# AGENTSCHAP LANDBOUW & ZEEVISSERIJ

Betreft: Morecambe Offshore Windfarm Generation Assets - Transboundary Consultation

The agency does not agree with Volume 5 Chapter 13 Commercial Fisheries and Appendix 13.1 Commercial Fisheries Technical Report in regards to the conclusion of the impact on the Belgian fisheries active in the Morecambe area.

Figure 5.22 Landings from the local study area by non-UK vessels 2012 to 2016 (EU DCF, 2022)

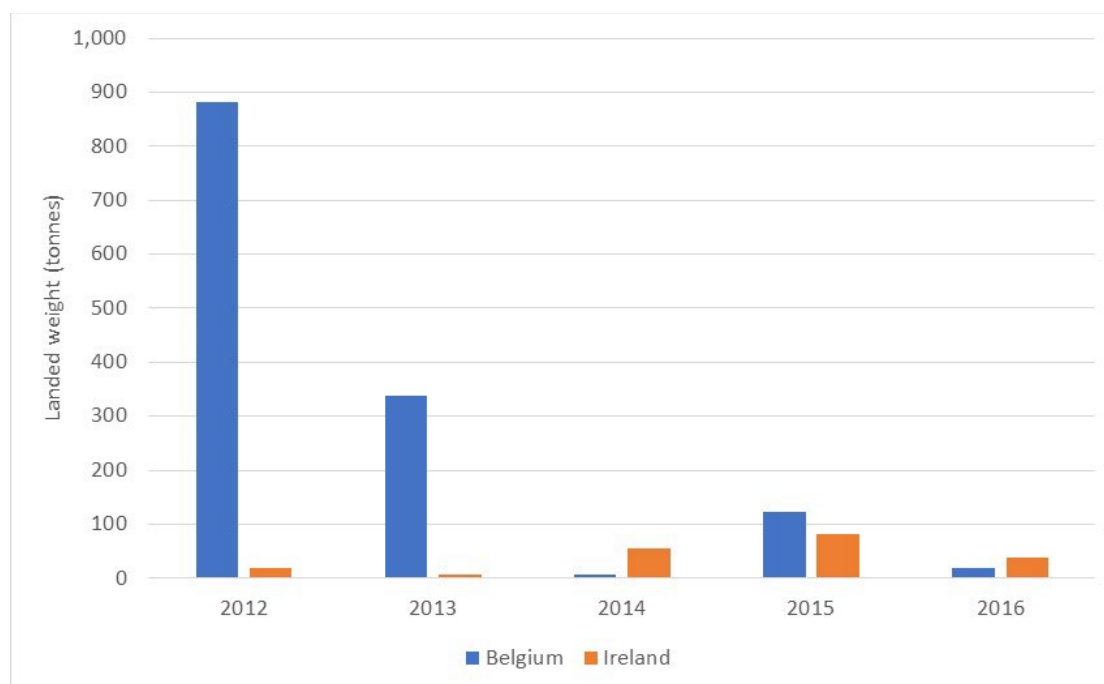
The Morecambe ICES rectangle 36E6 and surrounding area is an important area for the BE fisheries. Between 2019 and 2023 the landings of the area was on average 136 ton which account for at least 1% of the annual turnover of the Belgian fleet. The agency notices that the cited data used in the technical report were from 2012 to 2016, which are not recent data and does not reflect the current activity and importance of the area for the Belgian fisheries. Furthermore recent data suggest the opposite of the cited data and show quite high steady fisheries activity with some fluctuation but no sign of decrease.

Further the Agency is puzzled why there was no mention of any assessment of the possible impact of Brexit on the EU-fisheries within the chapter and the technical report, and due to the use of data before 2020 this is also not reflected in the outcomes.

The Flemish Agency of Agriculture therefore asks to reevaluate Chapter 13 and the conclusions made by the technical report. The Agency would like to continue monitoring the developments and is open to be actively involved in further discussions. We will also always be available to provide additional or more detailed information if needed.
